Our Ref: SE/CL/2015/39037/S

App Ref: 15/00153/REM
Site: Heyford Park, Camp Road, Upper Heyford, Bicester, OX25 5HD
Proposal: “Reserved Matters to Outline application 10/01642/OUT - Village green including sports provision.”

1. ‘Village Green – Detailed Landscape Proposals’ (drawing numbered Bir.4322_18K)
2. ‘Village Green – Site Location Plan’ (drawing numbered D.0341_66)
3. A covering letter from Pegasus Group dated 22nd July 2015.

Village Green Landscape Proposals
Scale 1:200

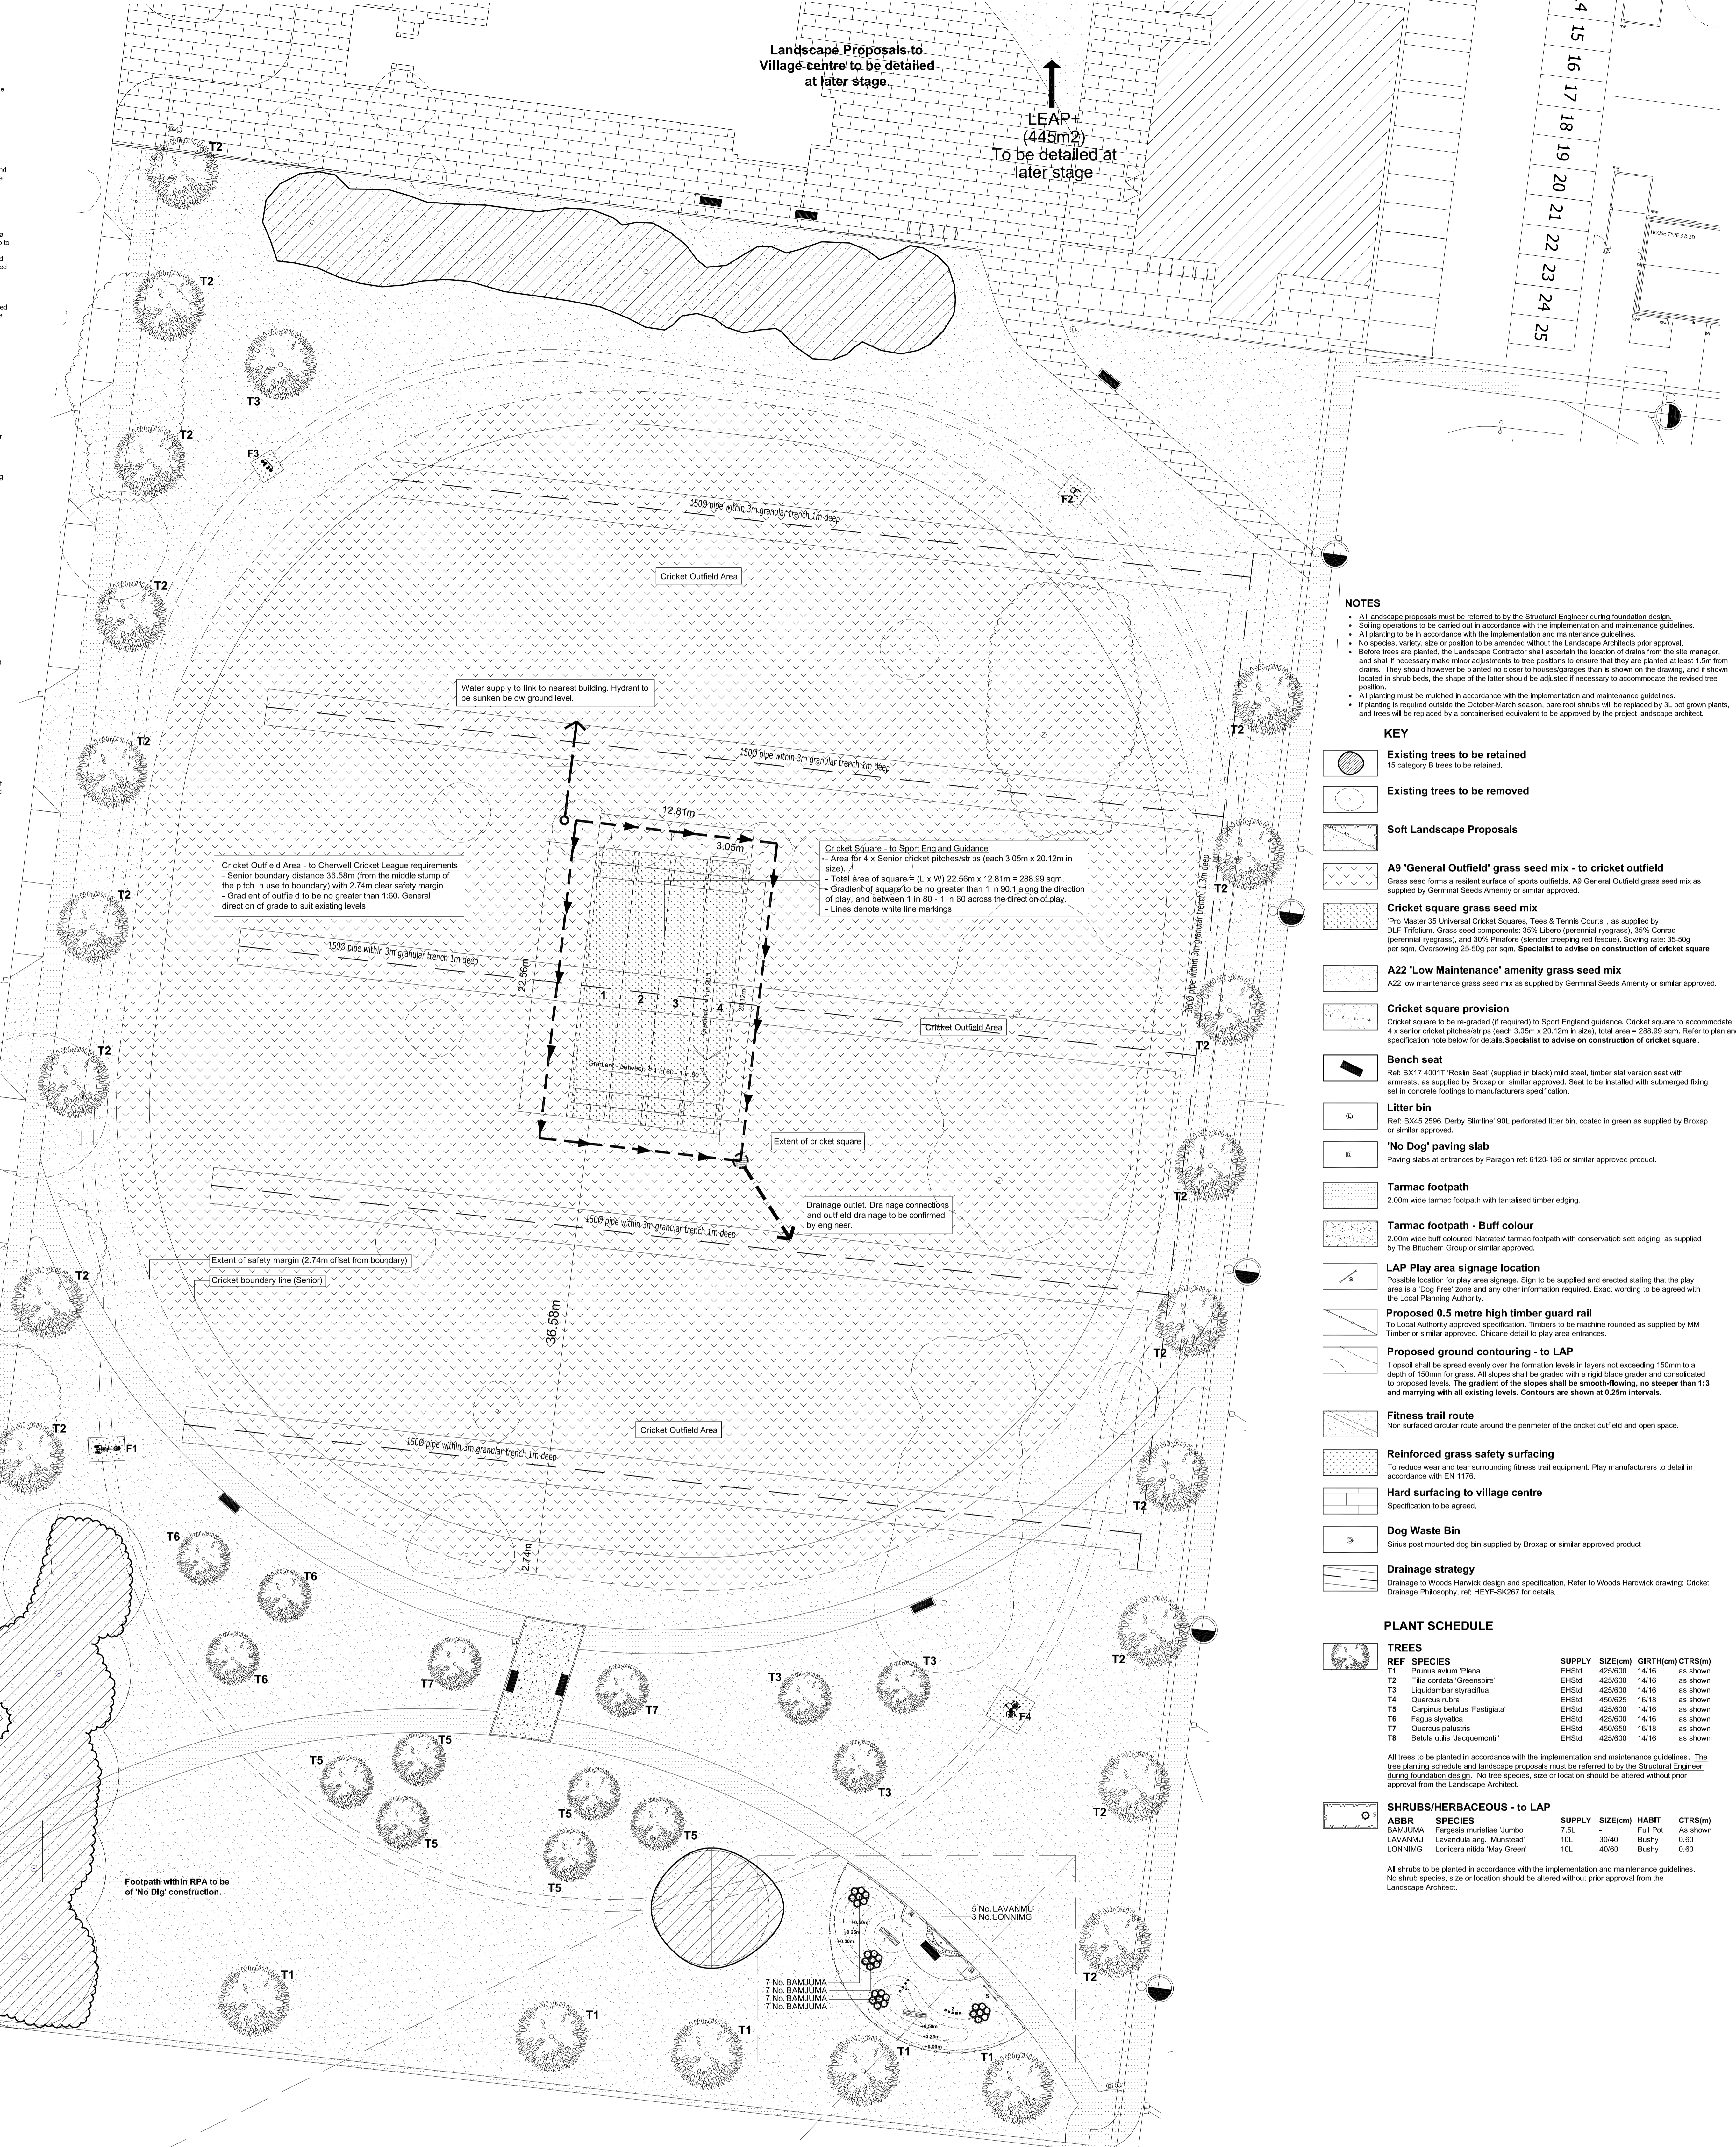
The revised drawings show a different shaped site, to that which was considered previously for the village green, and a cricket square comprising four grass wickets instead of one artificial wicket. The minimum recommended distance, from the middle stump to the boundary of the outfield, for a senior pitch is shown (i.e. 45.72m). The covering letter states that “a Health and Safety Report considering cricket ball trajectories and safety net specifications will follow to accompany these revised details”. At the time of preparing this response to consultation, neither the report nor specification have been submitted.

Having regard to the matters raised previously, in its letter dated 5 May 2015, Sport England does not wish to raise an objection to the revised proposal, **subject to** the following conditions being attached to the decision notice (if the Council is minded to approve the application):

The cricket pitch hereby permitted shall not be constructed other than substantially in accordance with the ECB's Recommended Guidelines for the Construction, Preparation and Maintenance of Cricket Pitches and Outfields at all Levels of the Game.

- a) No development shall commence [or other specified time period] until the following documents have been submitted to and approved in writing by the Local Planning Authority [after consultation with Sport England]:
 - (i) A detailed assessment of the risk of cricket balls leaving the ground and potential solutions to reduce the risk to an acceptable level.
 - (ii) Based upon the results of the assessment to be carried out pursuant to (i) above, a scheme that is designed to prevent balls from leaving the playing field area. The scheme shall include full details of all structures to be erected, who will have control over them and who will be responsible for their maintenance.
- b) The approved scheme shall be carried out in full before first use of the cricket pitch. The land shall thereafter be maintained and made available for playing field use in accordance with the scheme.
